**RESPONSE TO AGENCY ADVICE - SECTION 4.55(2) MODIFICATION APPLICATION (SSD-6957-Mod-1)  
CROWN SYDNEY HOTEL RESORT**

This letter has been prepared on behalf of the applicant, Crown Sydney Property Pty Ltd (**Crown**), in response to further correspondence received from the City of Sydney (**Council**) regarding a S4.55(2) Modification Application SSD-6957-Mod-1 (**Modification Application**) relating to the approved Crown Sydney Hotel Resort Development Consent SSD 6957 (**Development Consent**), located at 51a Hickson Road, Barangaroo, NSW.

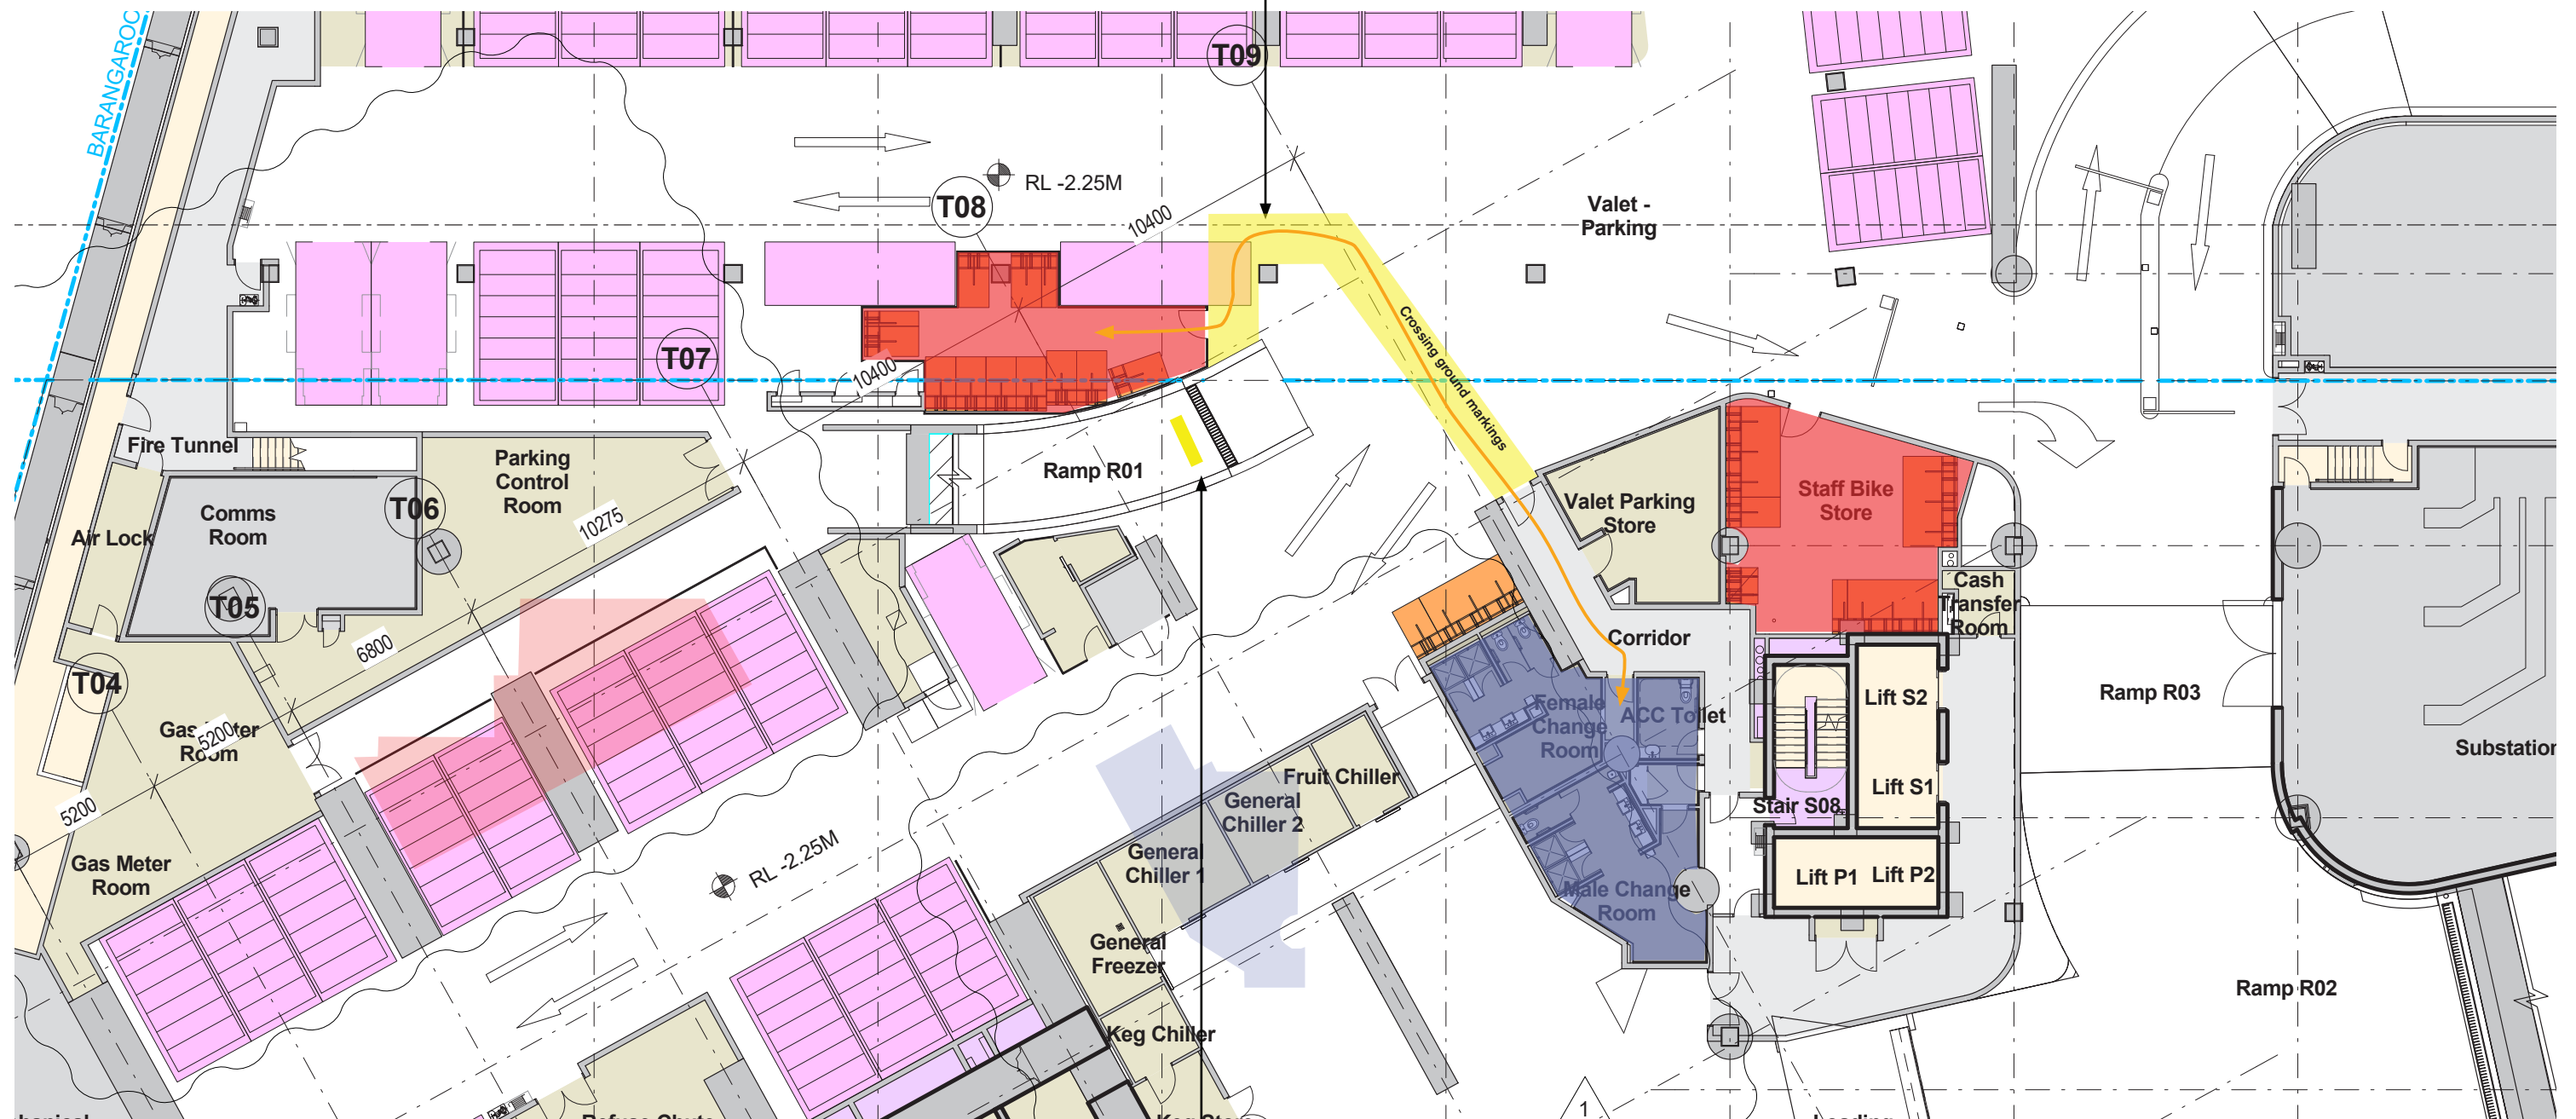
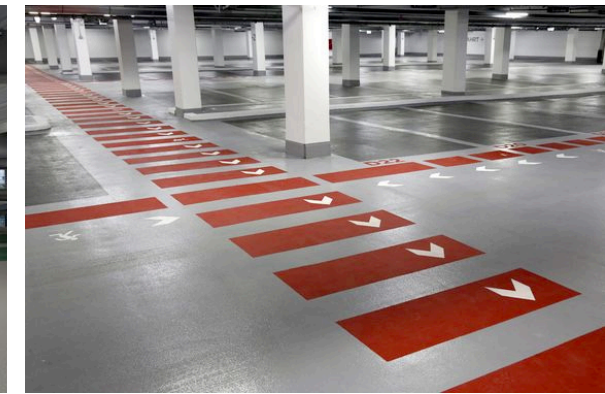
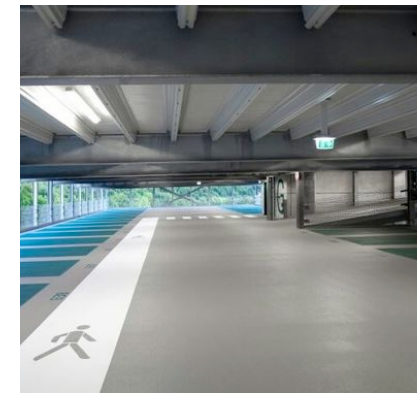
Council note that staff end of journey and bicycle parking are separated by a valet ramp, which it considers may pose a safety risk. In response, Crown notes that only some of the bicycle parking is separated from the staff shower/change rooms facilities. It is also worth highlighting that the intention has always been to provide appropriate wayfinding and ground markings to provide a safe path of travel for the designated pedestrian movement locations which are located by the valet ramp entry, please refer to the Safe Path of Travel signage documented at **Attachment B**. These plans consolidate pedestrian movement in front of the valet ramp entry to a single crossing location with appropriate ground markings and signage to caution valet drivers and attract their attention. This area will be well lit and be complemented by suspended signage on the valet ramp instructing drivers to be aware of pedestrians crossing.

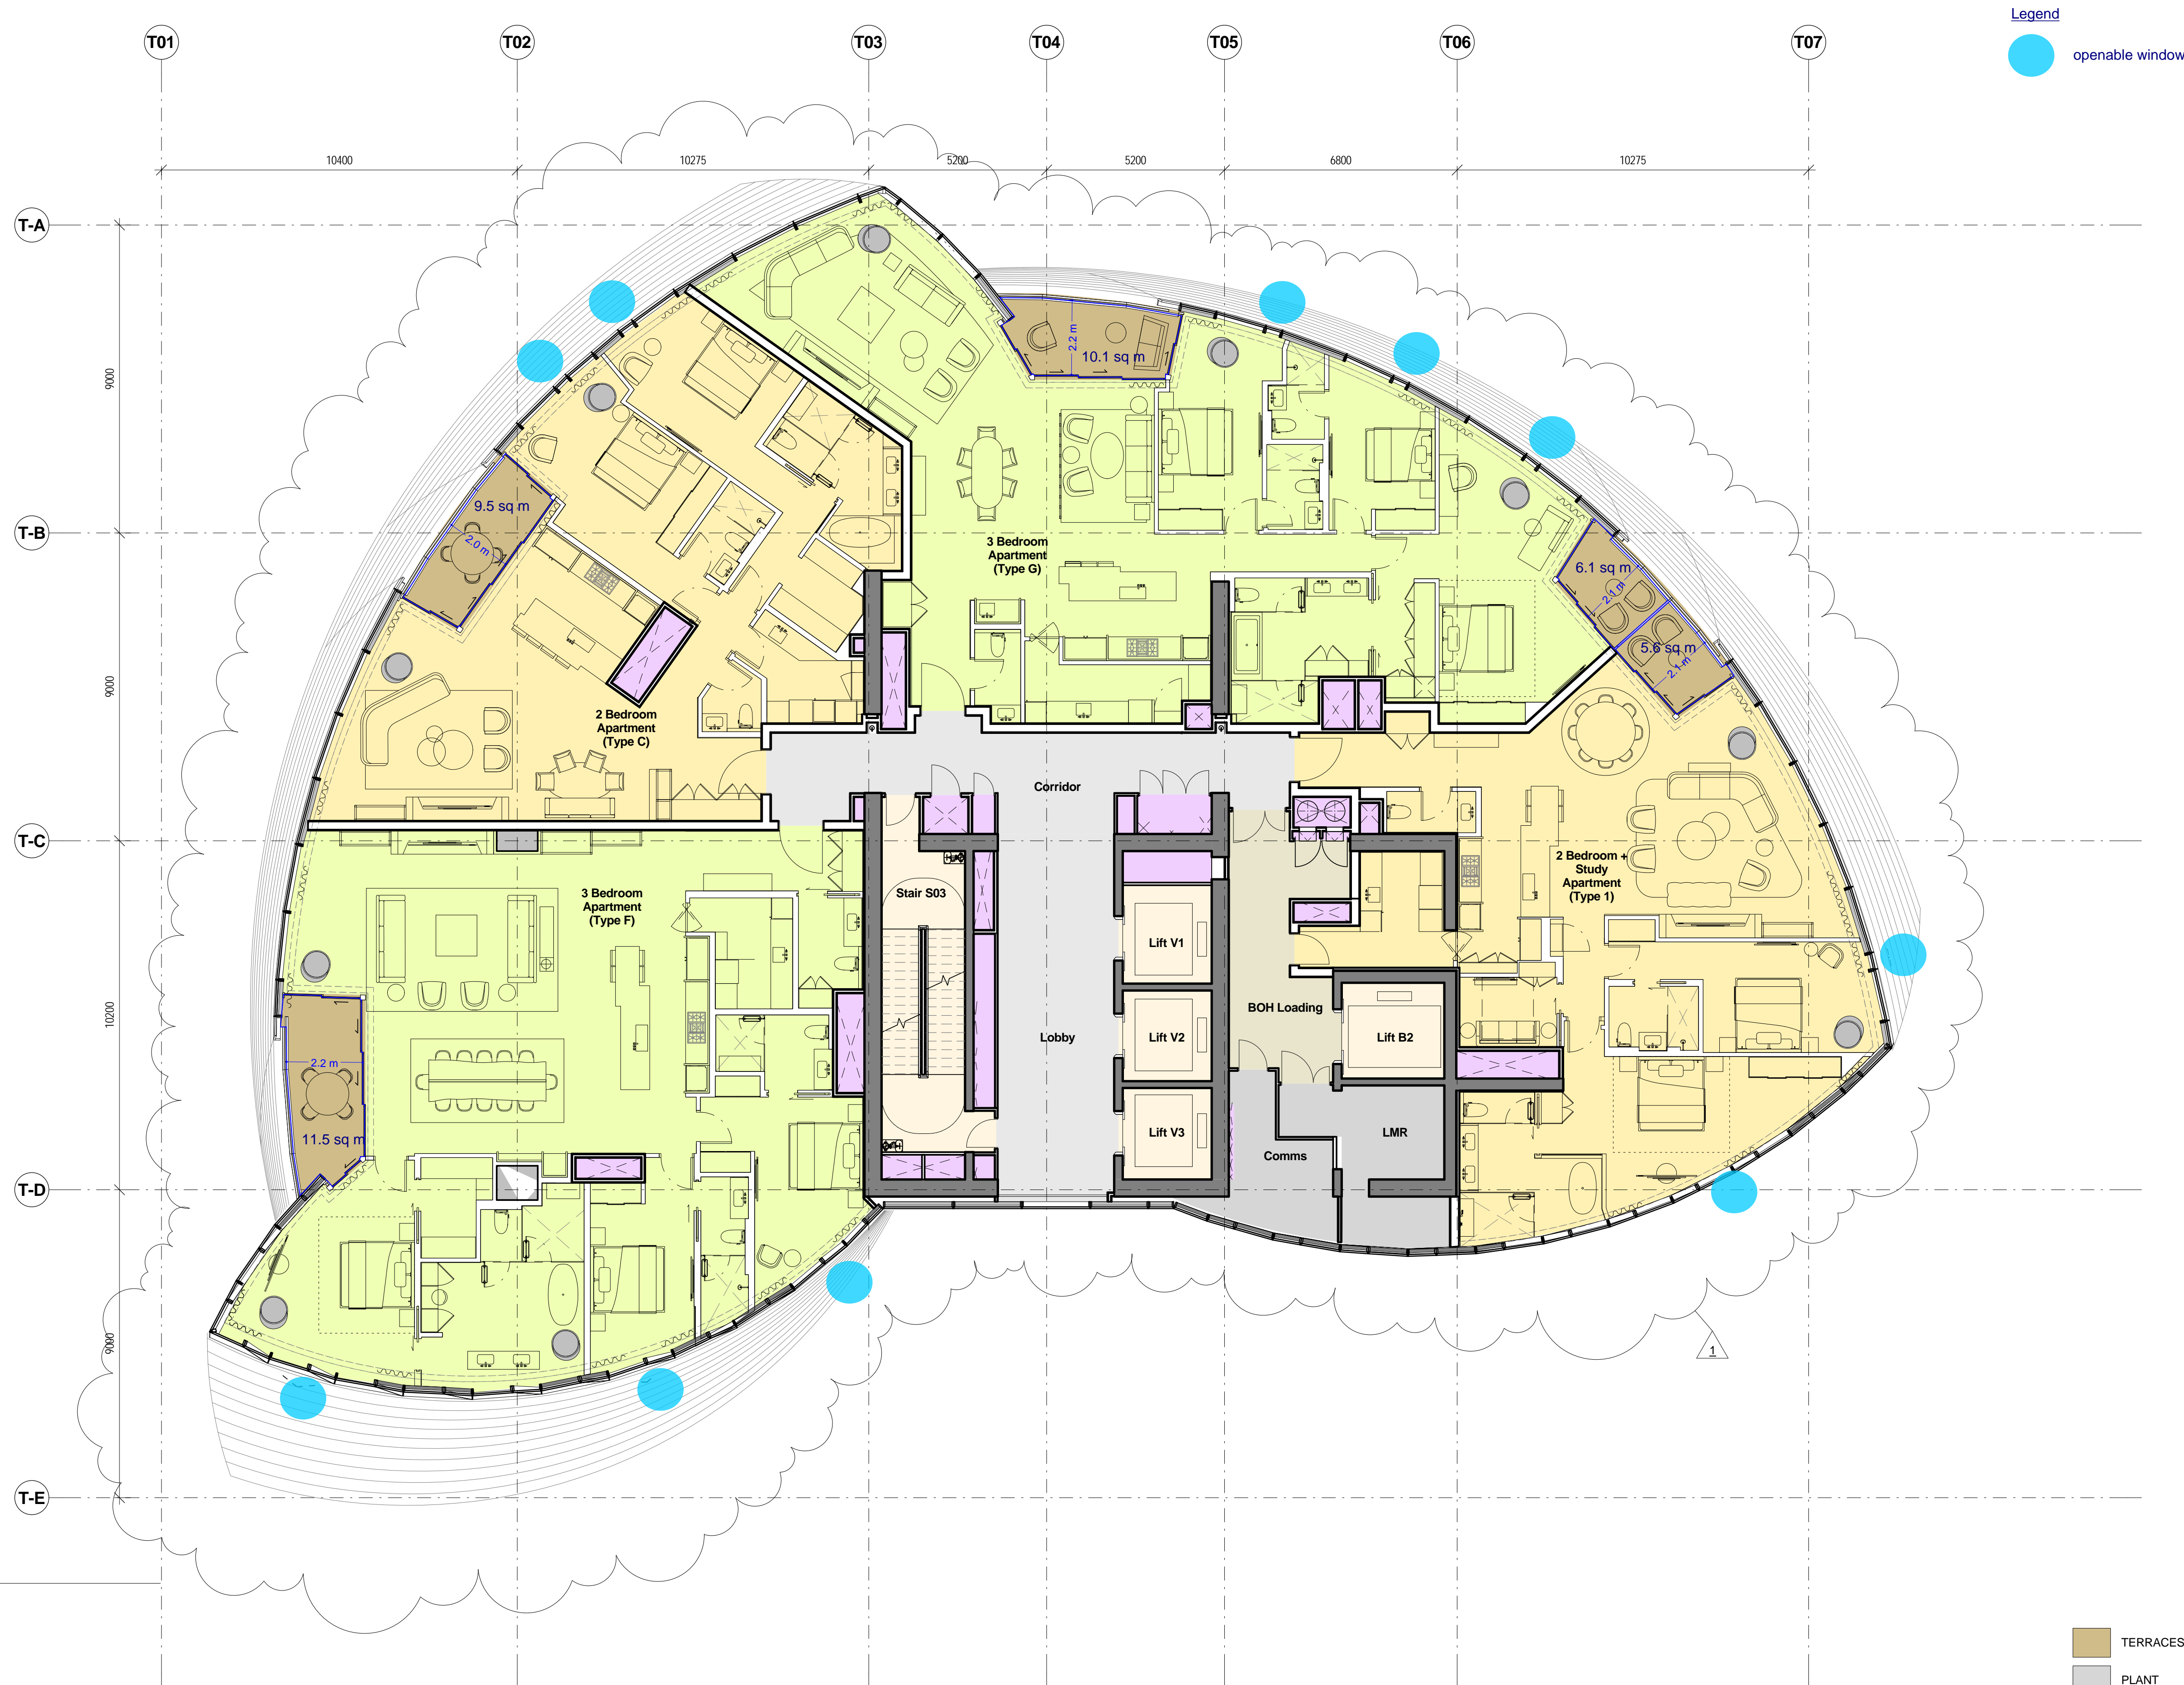
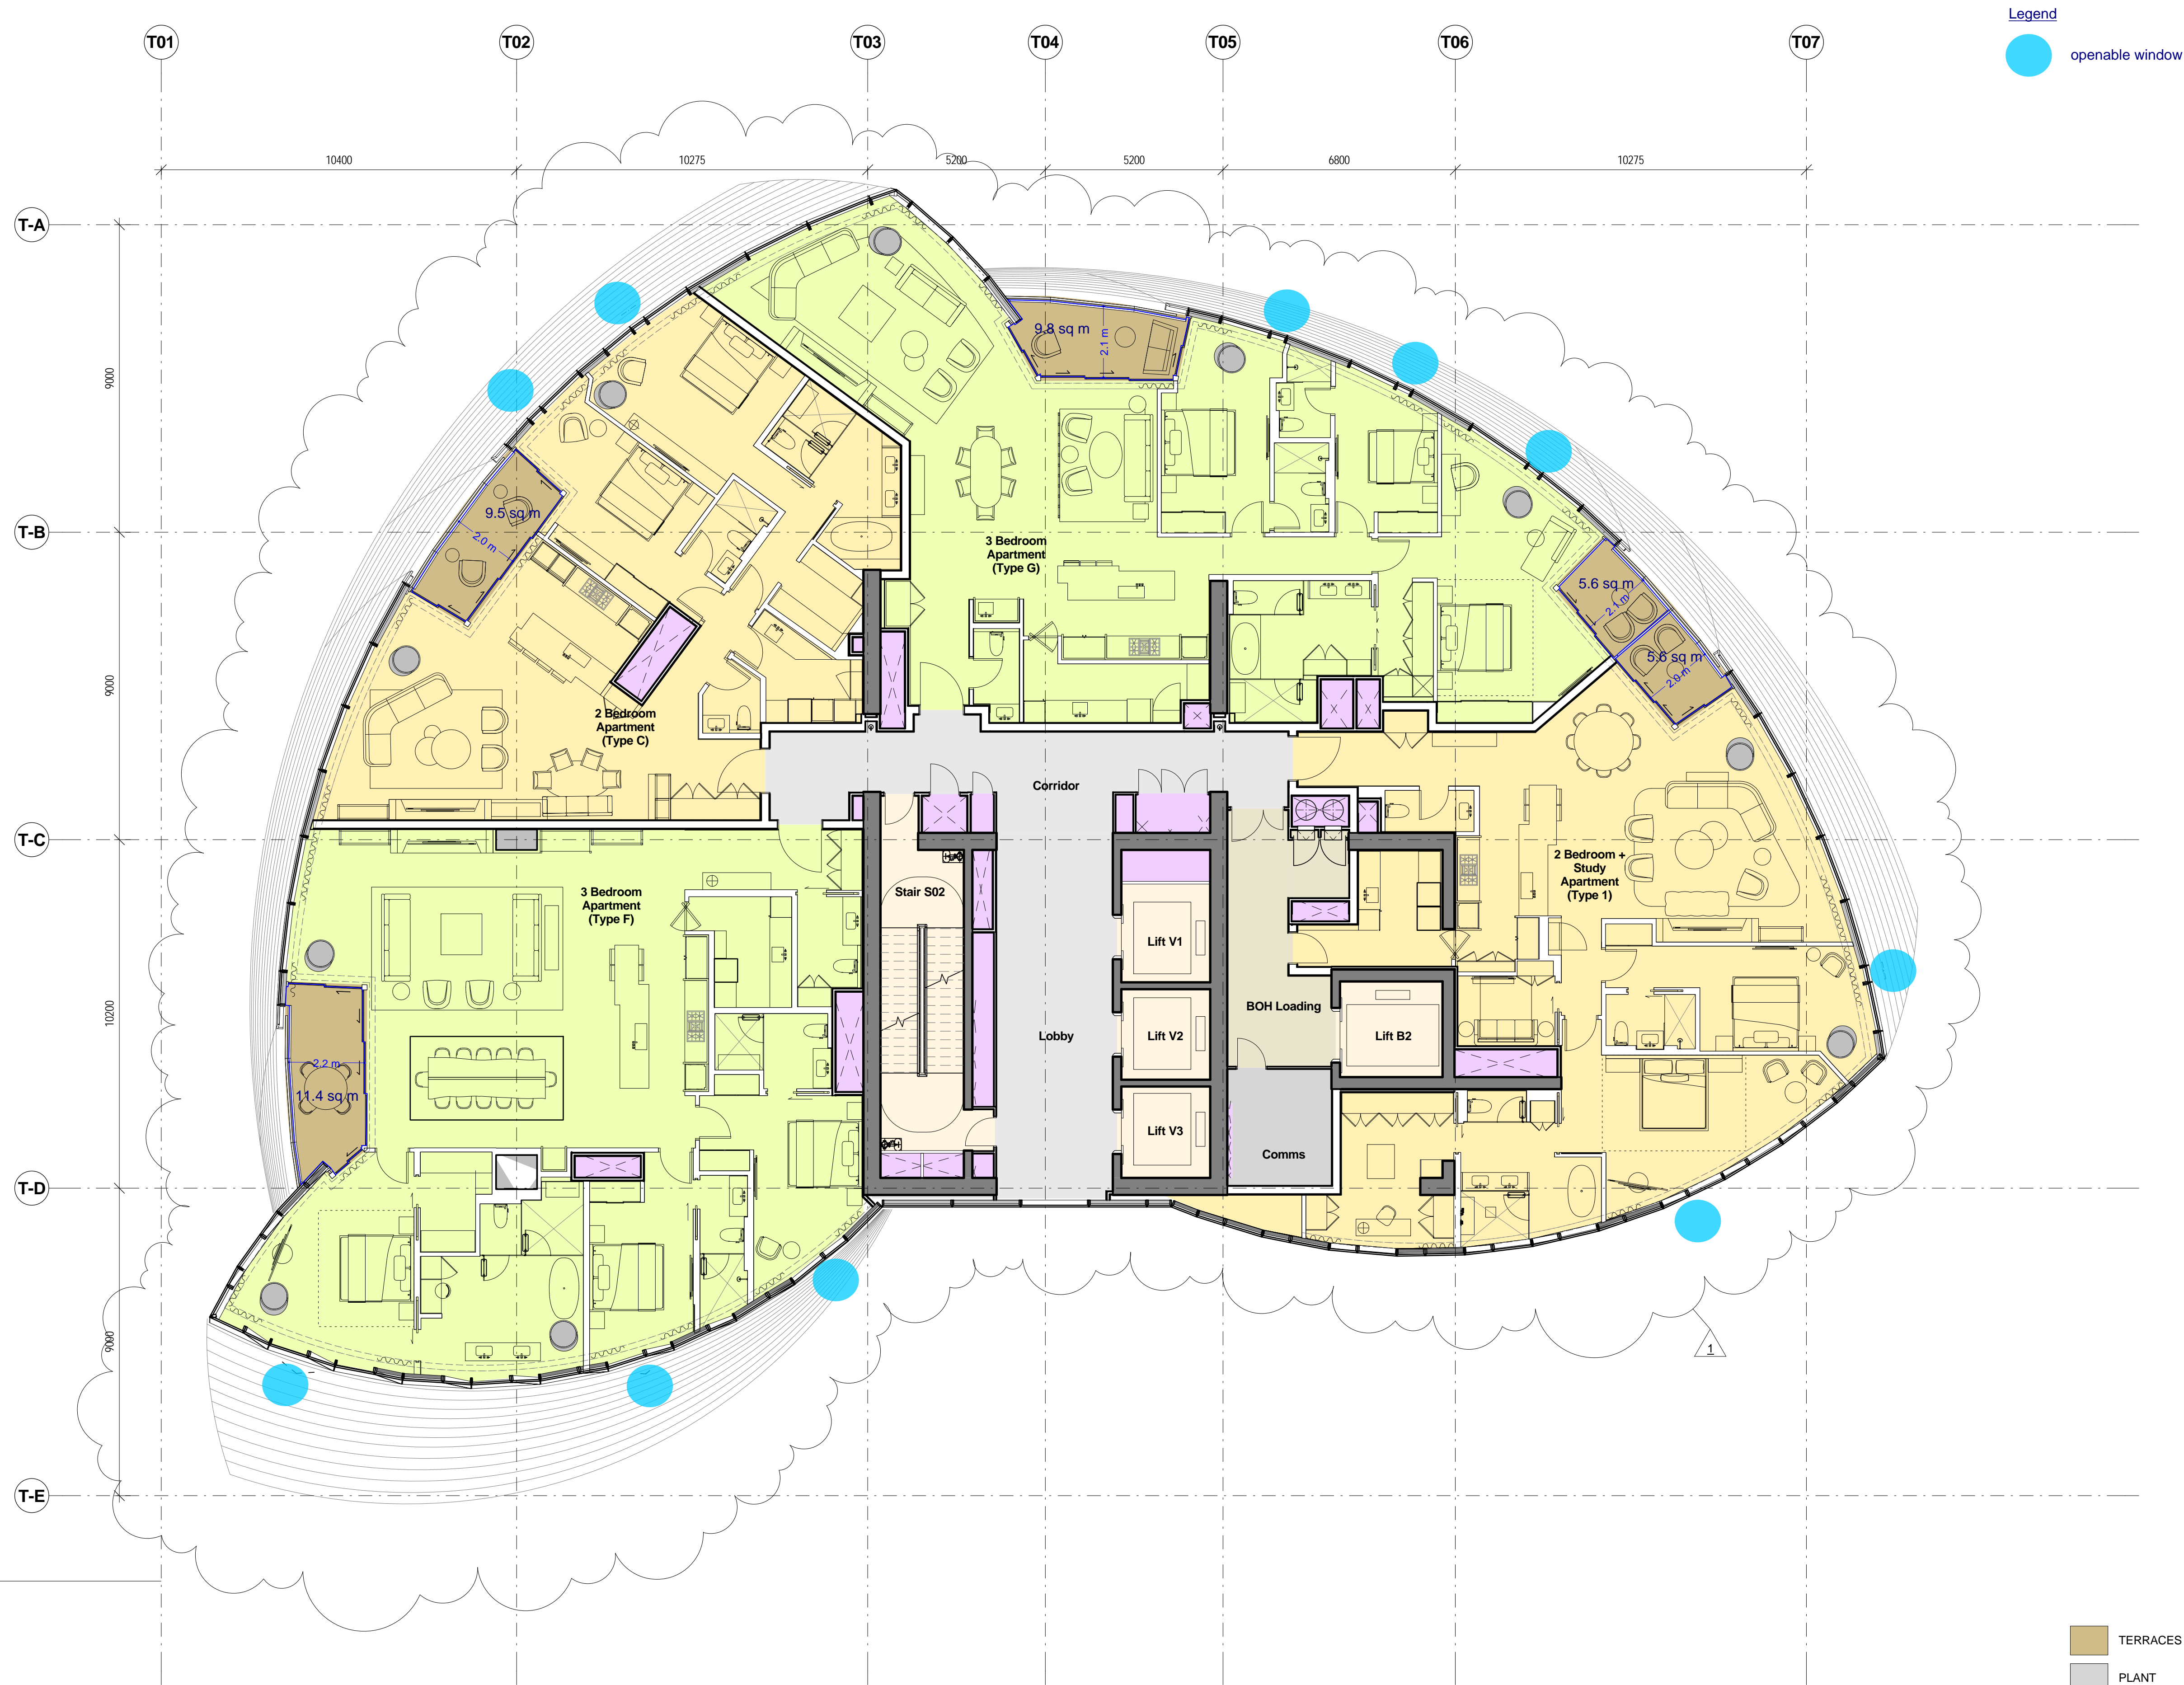
The ADG also states that to conform with the high wind balcony concession, *Natural ventilation also needs to be demonstrated*. The proposed design includes the provision of operable windows for natural ventilation to all apartments. These have been shown, for clarity, in **Attachment C**.
